From: [Julie Chivo](#)
To: [Robin Proebsting](#)
Subject: East Seattle School subdivision
Date: Sunday, June 23, 2019 9:21:46 PM

I would like to continue to receive updates about the plans for the Old Boys&Girls Club building on West Mercer Way.

**PRELIMINARY ROAD PLAN &
SECTIONS**

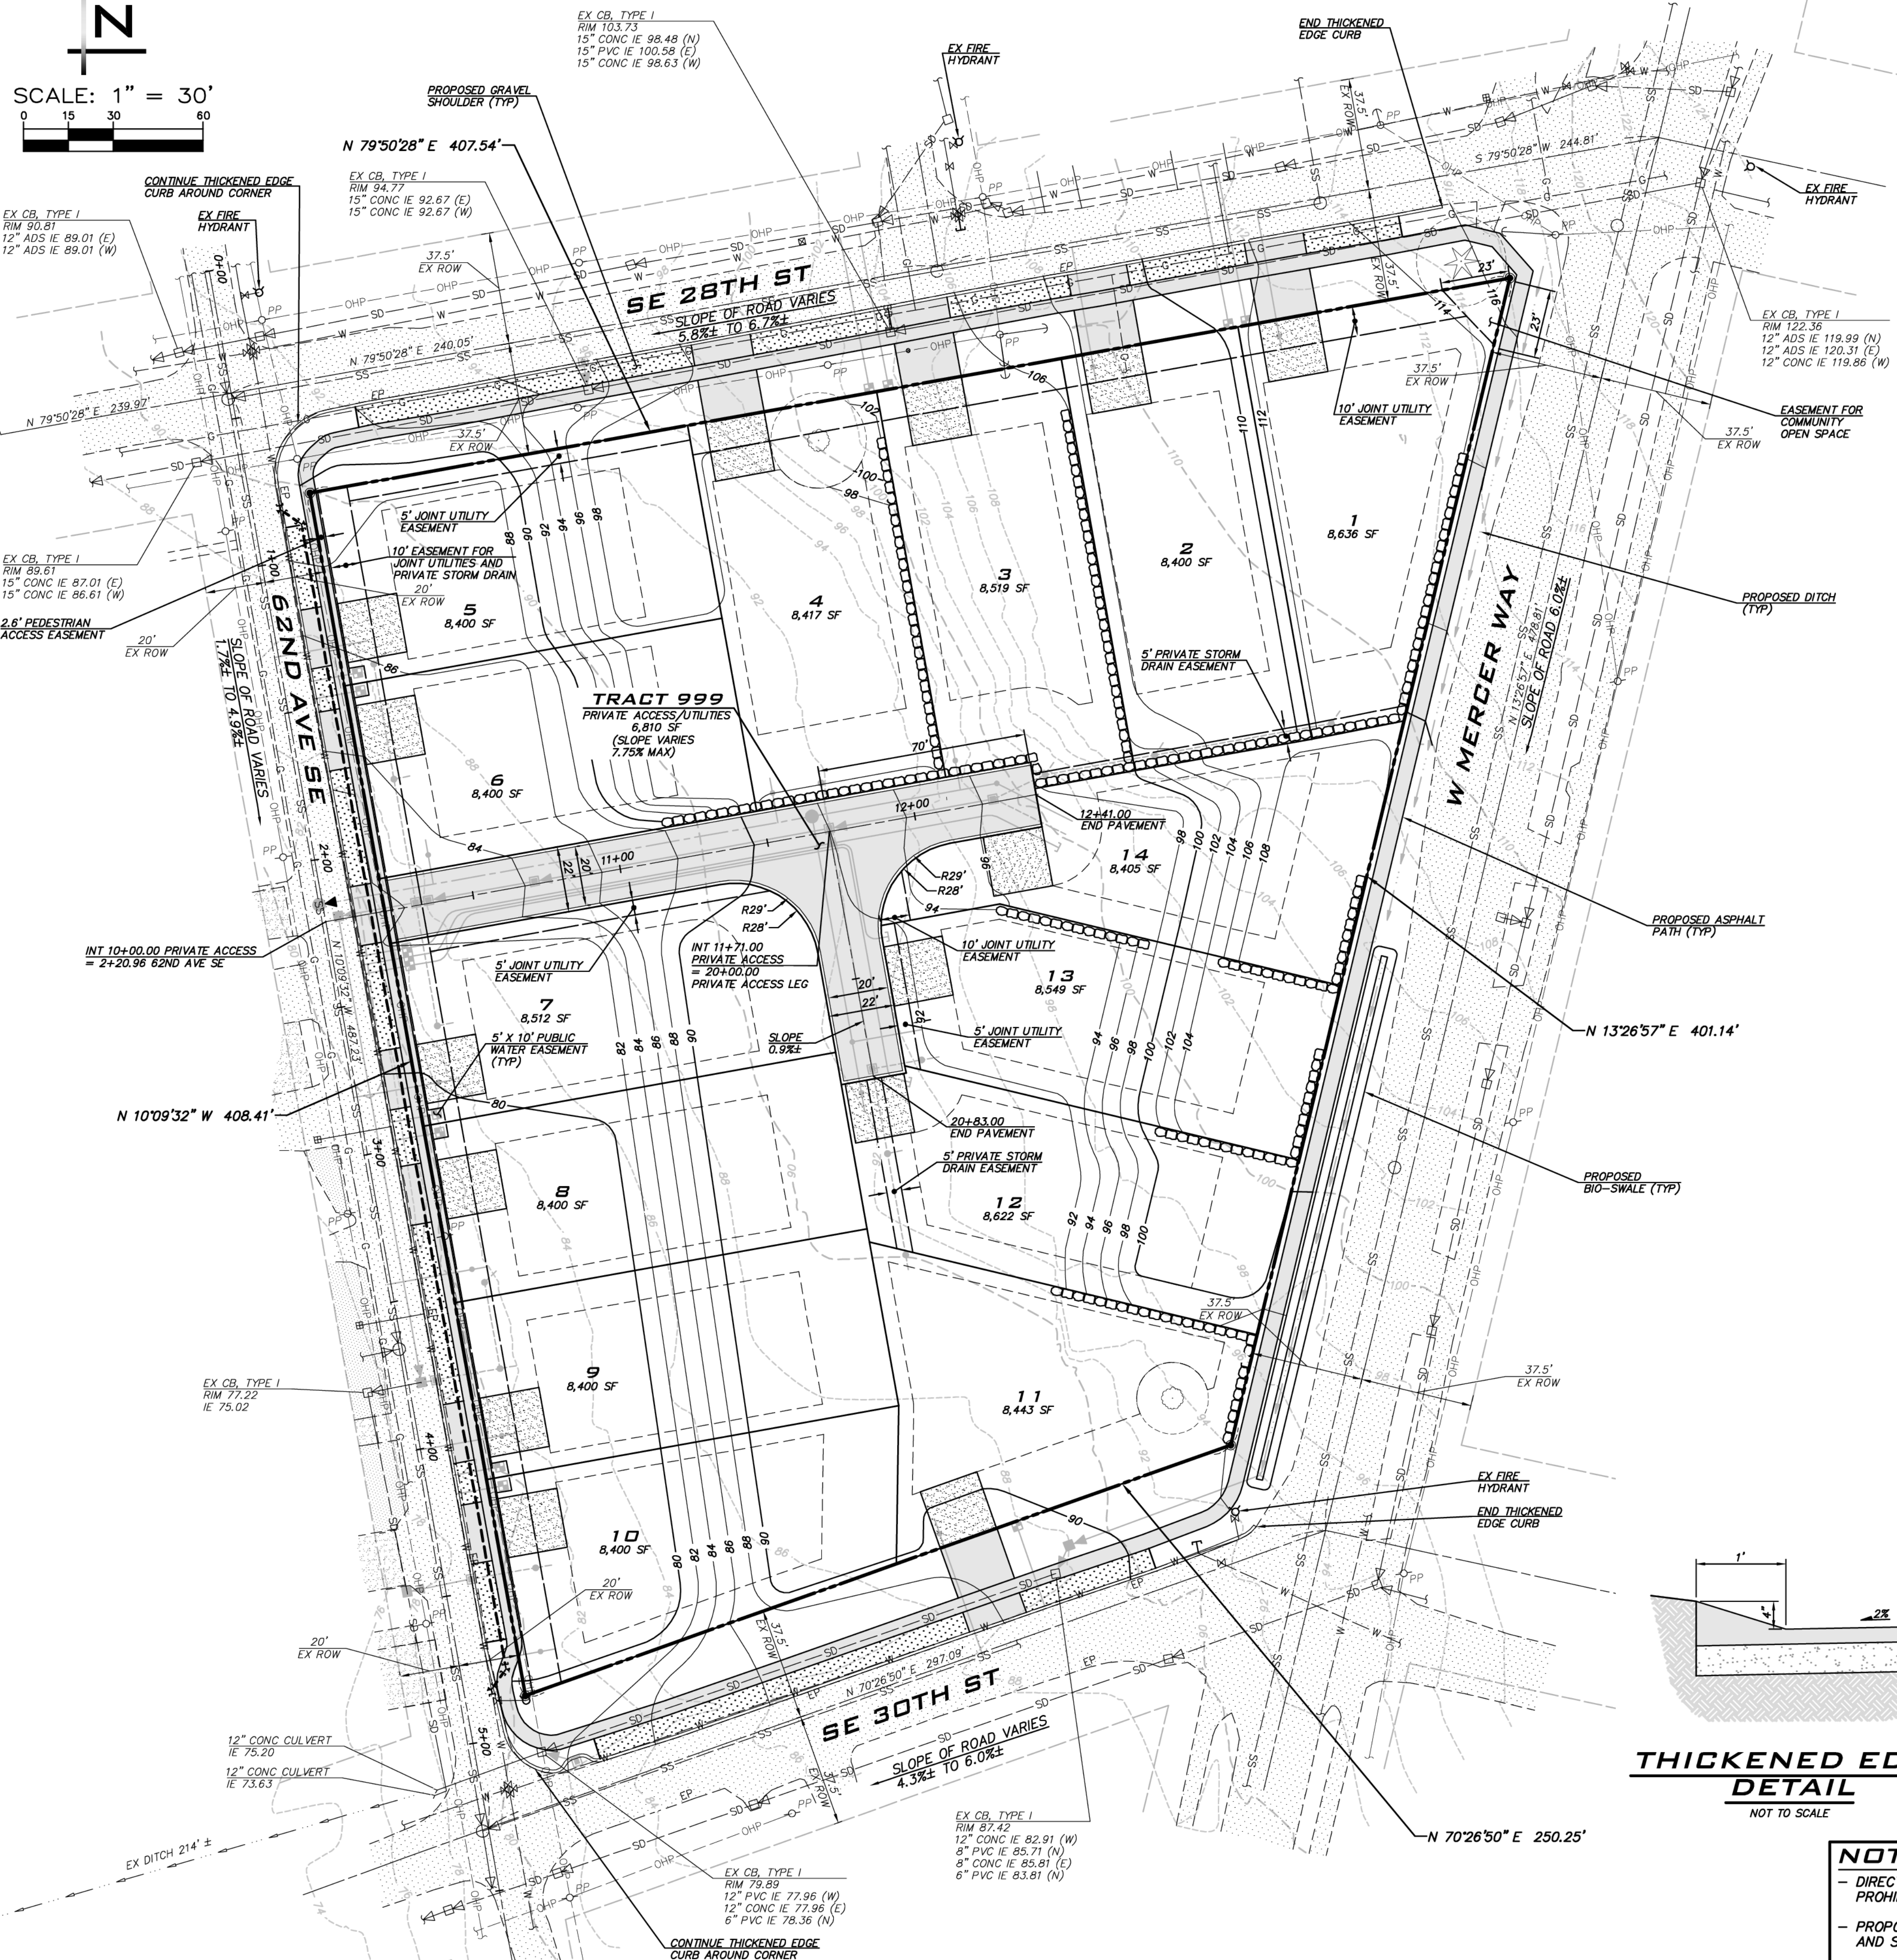
I was at the meeting that was held on Thursday night, until 6:45. I thought a good point was made by a resident that said she lived on 62nd Ave. SE. she pointed out that this is a very narrow street. If 10 residences will be accessing their homes through 62nd Ave, this street should be widened for better access. Alternatively, the plat could be rearranged so that the access road comes off of on of the other streets. 62nd seems like a strange choice because it is so tucked away.
